RE: DRAINAGE REPORT FOR PICO LA CUEVA SUBDIVISION (C-20/D15)
RECEIVED NOVEMBER 12, 1996 FOR FINAL PLAT & WORK ORDER
ENGINEER'S STAMP DATED 11-07-96

Based on the information included in the submittal referenced above, City Hydrology accepts the Drainage Report for Final Plat & Work Order:

RE: Pico La Cueva Subdivision

I have reviewed the Grading and Drainage Plan for the Pico La Cueva Subdivision, City Project #556781, and visited the site. The subdivision is in substantial compliance with the Grading Plan and Drainage Report.

TITLE: PICO LA CUEVA SUBDIVISION
GRADING & DRAINAGE PLAN

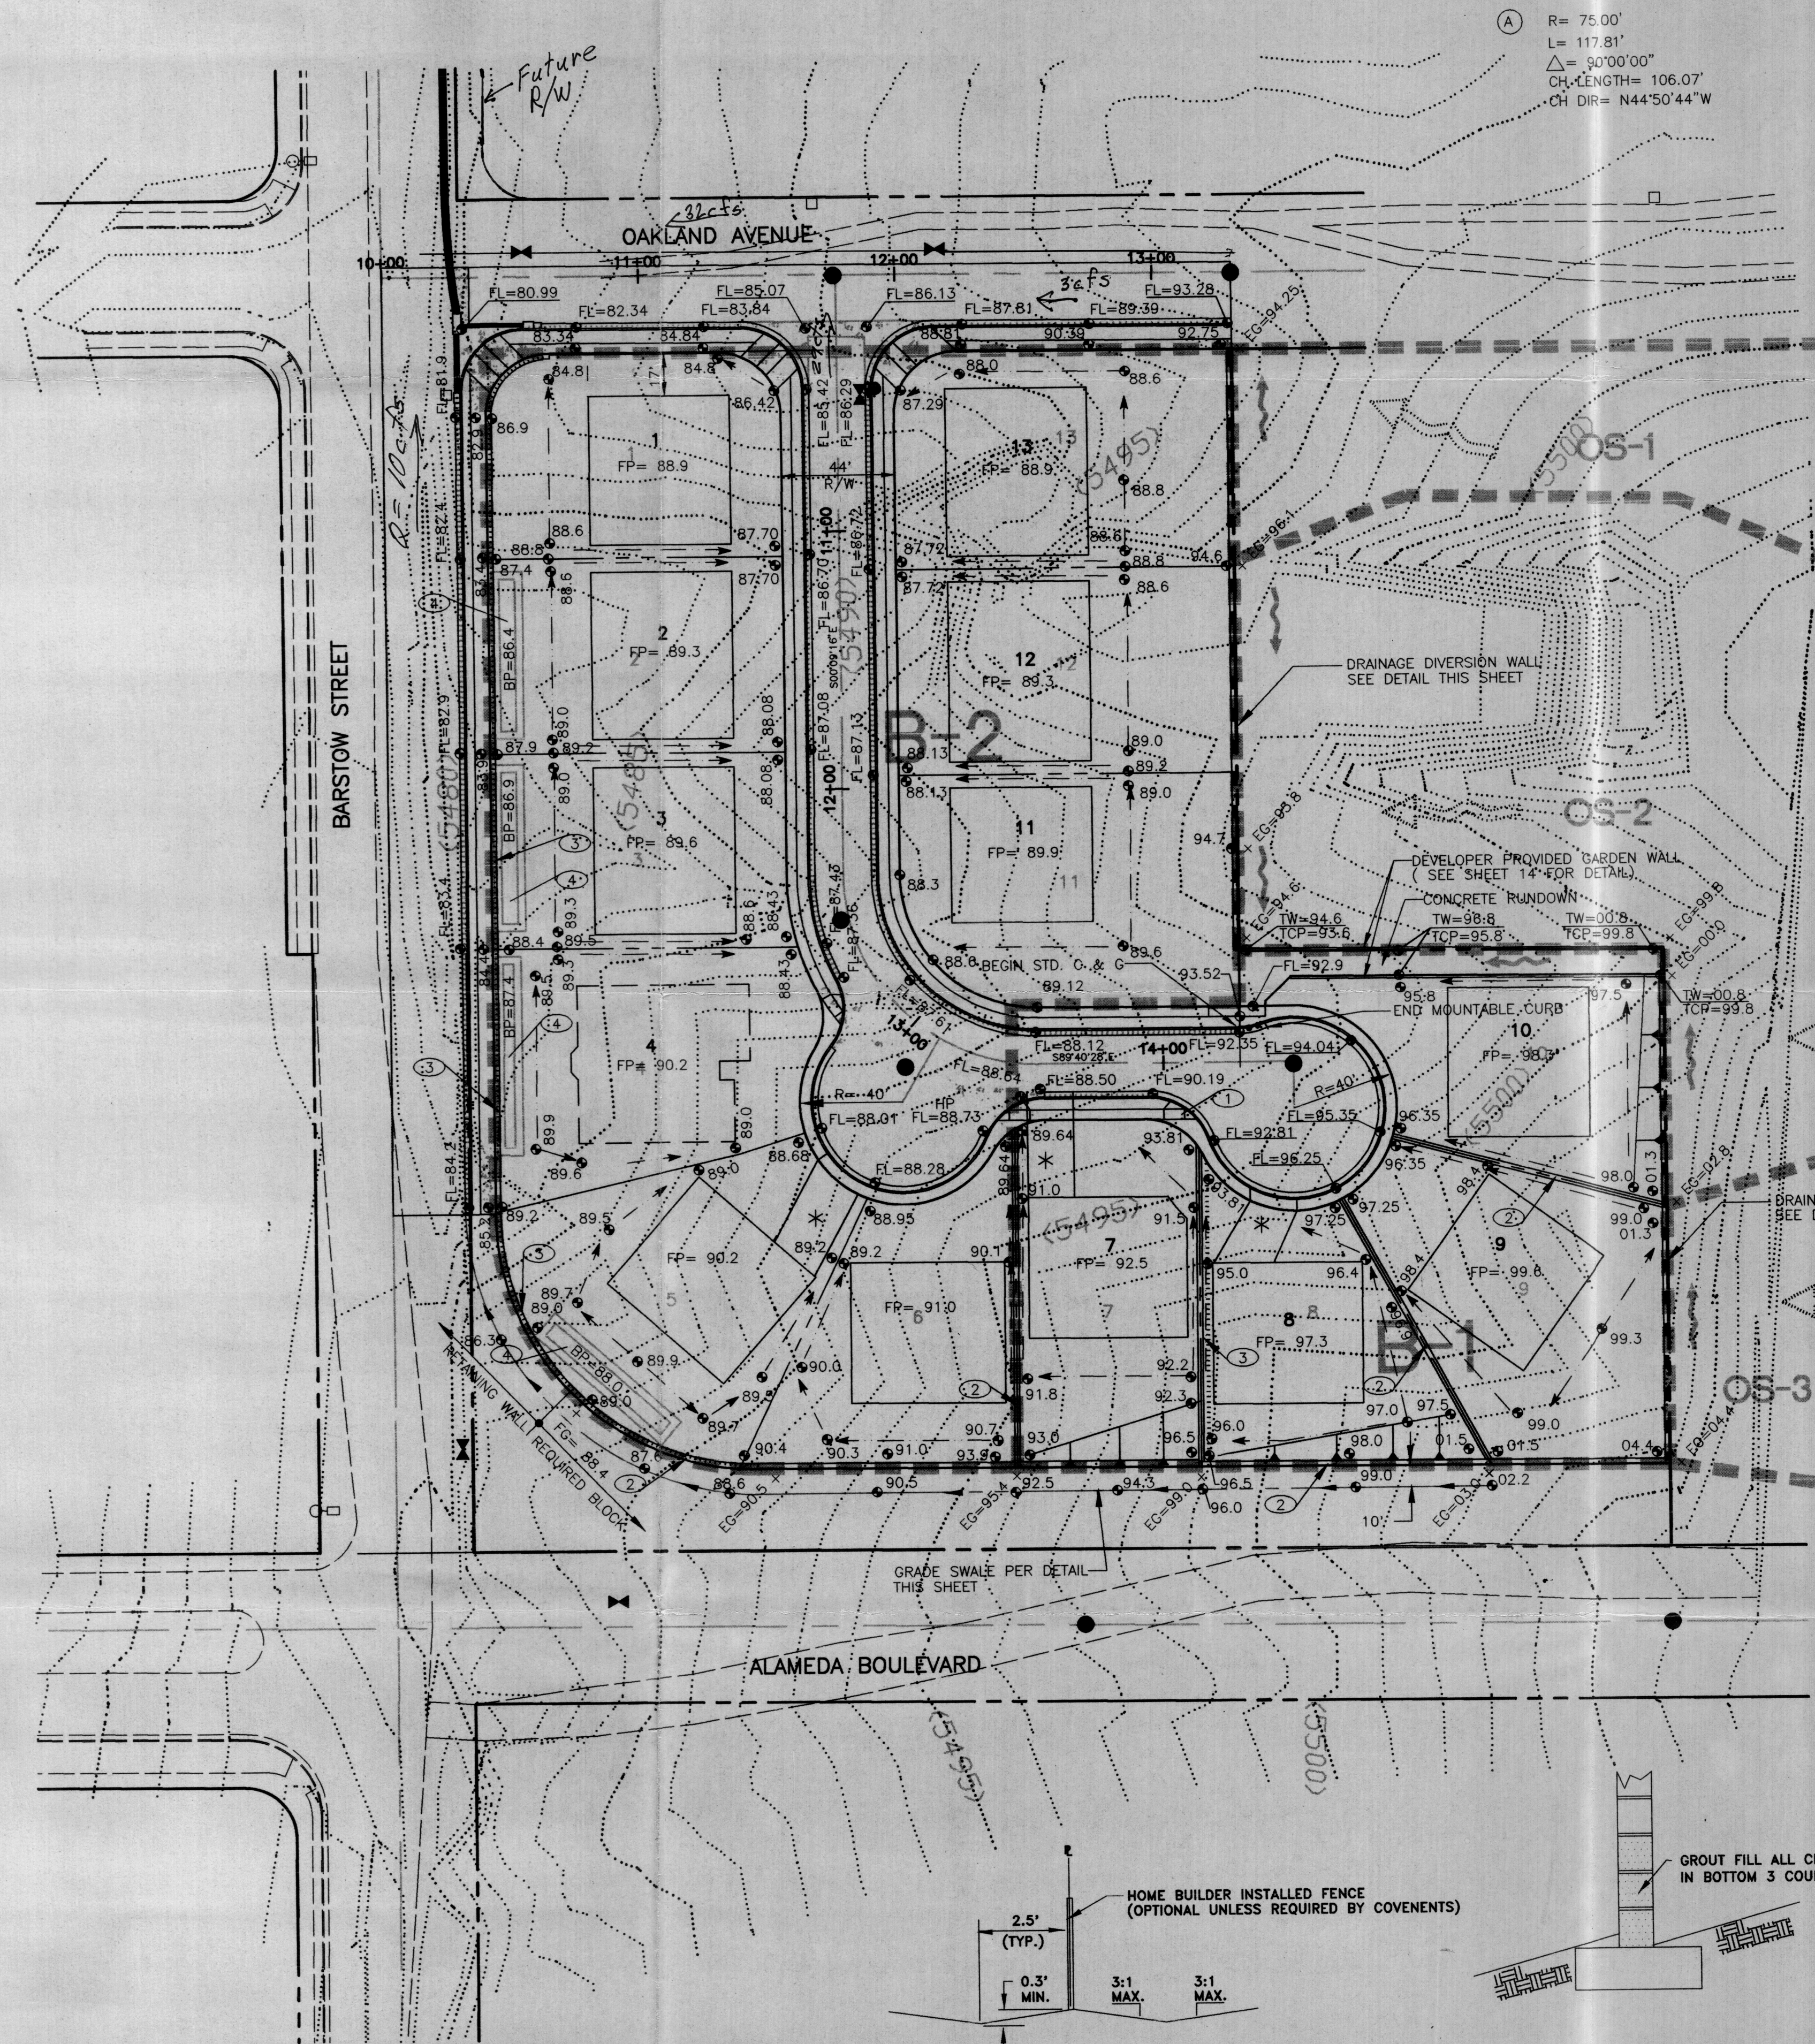
The retaining wall shown on the plan is built up to Lot 5. Approximately 80 feet of retaining wall needs to be built in order for the subdivision to be in full compliance. This certification assumes the retaining wall along Barstow Street was inspected and accepted by a City inspector when it was constructed. The perimeter wall will be built by the individual lot owners.
